Subject: CM/27/19/DOC

CM/27/19/DOC

MILL COTTAGE: DOORS AND WINDOW DETAILS 1:5 @ A3

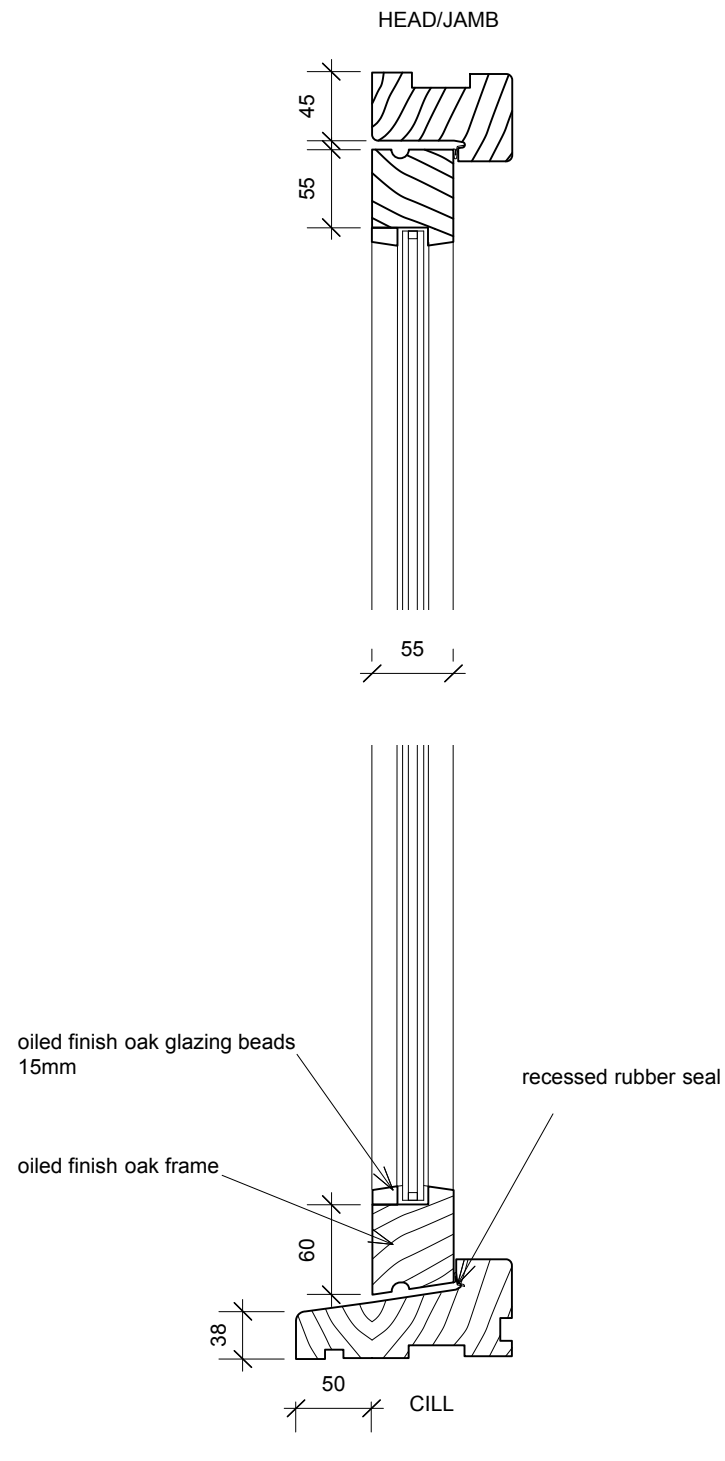
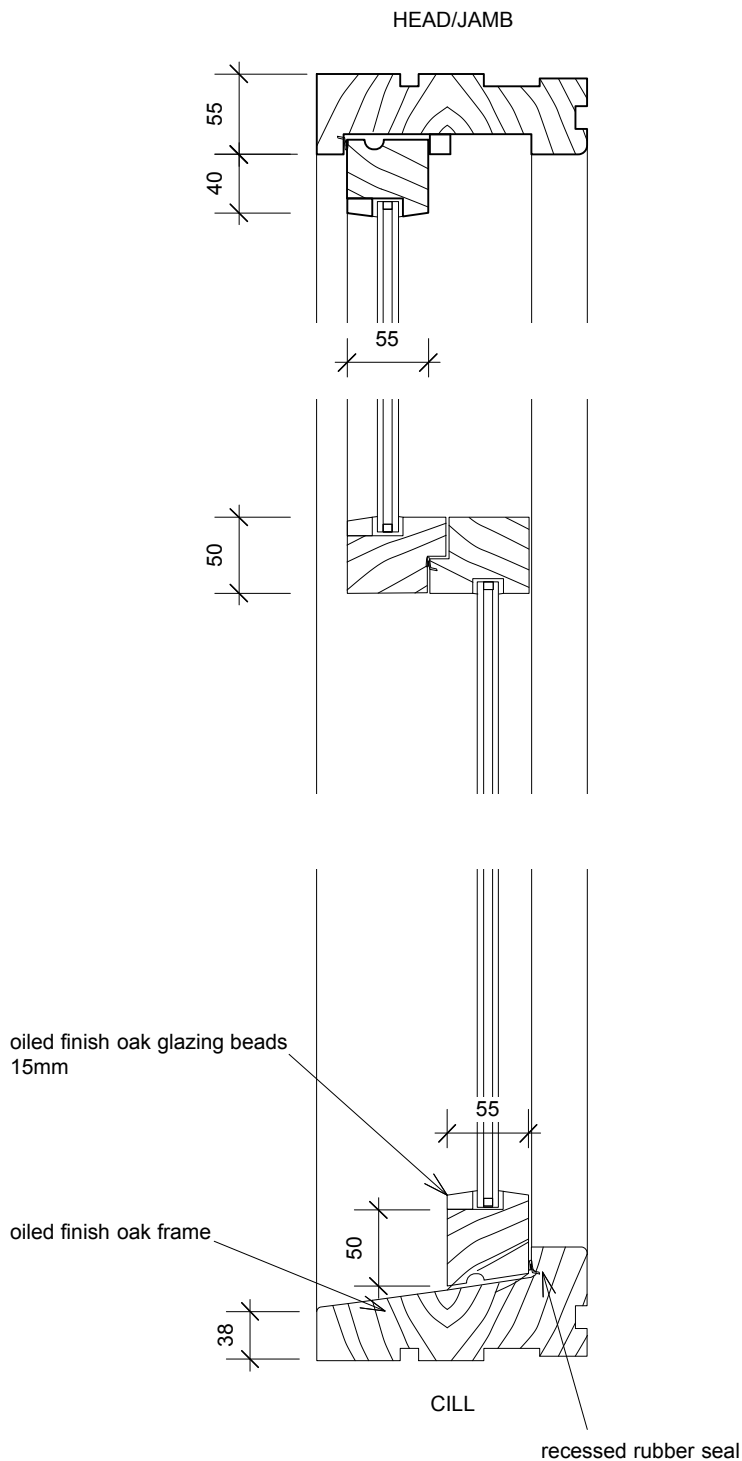
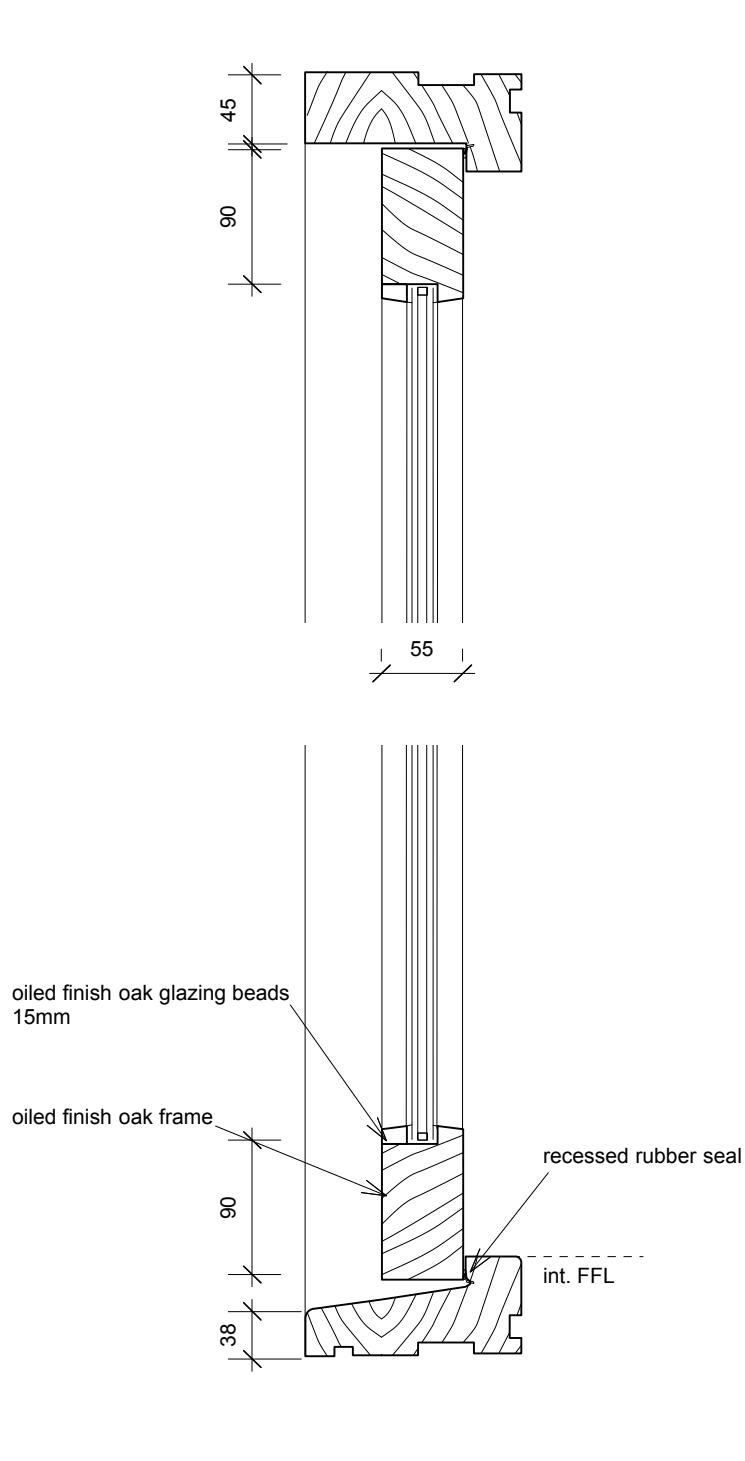
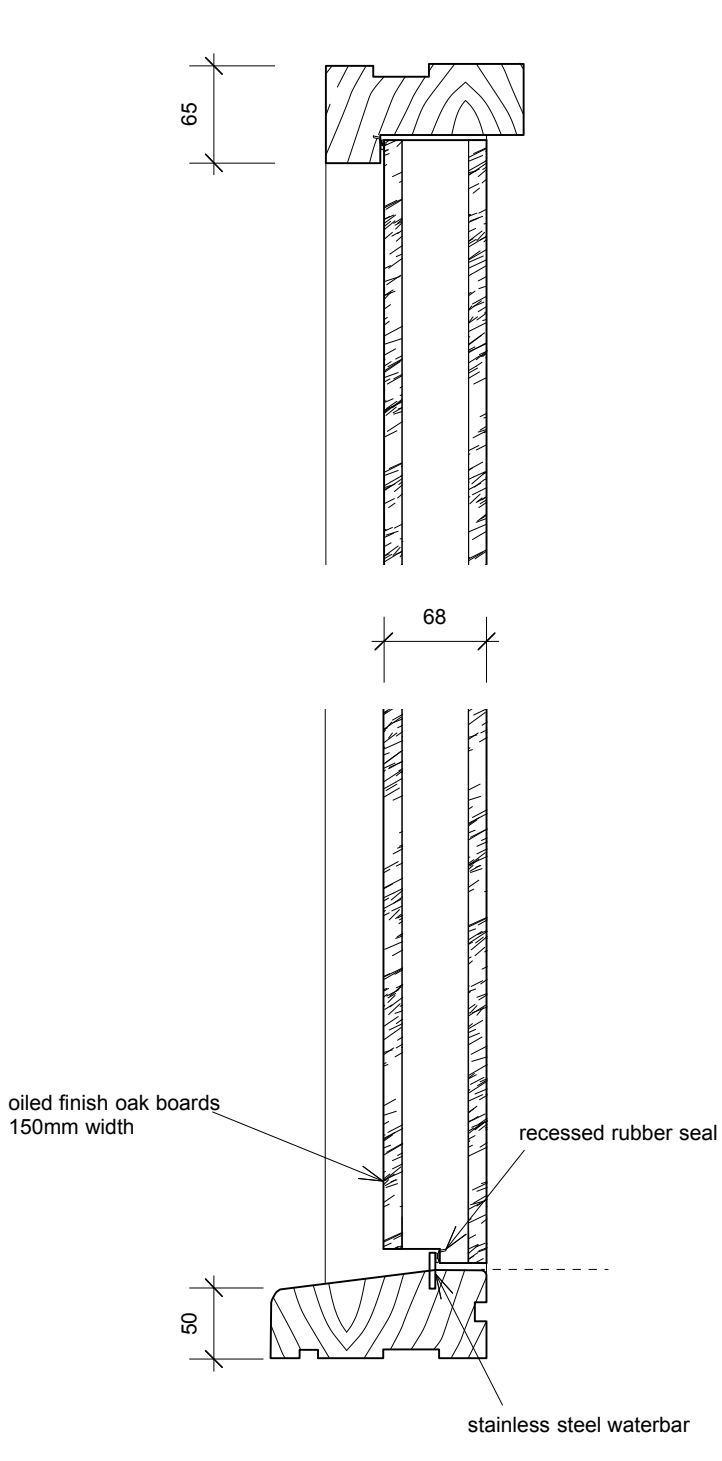
I have reviewed the details and it is not clear if the glazing is slimlight or standards thickness. The approved application refers to 14 mm slimline double glazing. Do the drawings provided as part of the DOC correspond with that approval?

If the glazing reflects the original permissions, they are acceptable.
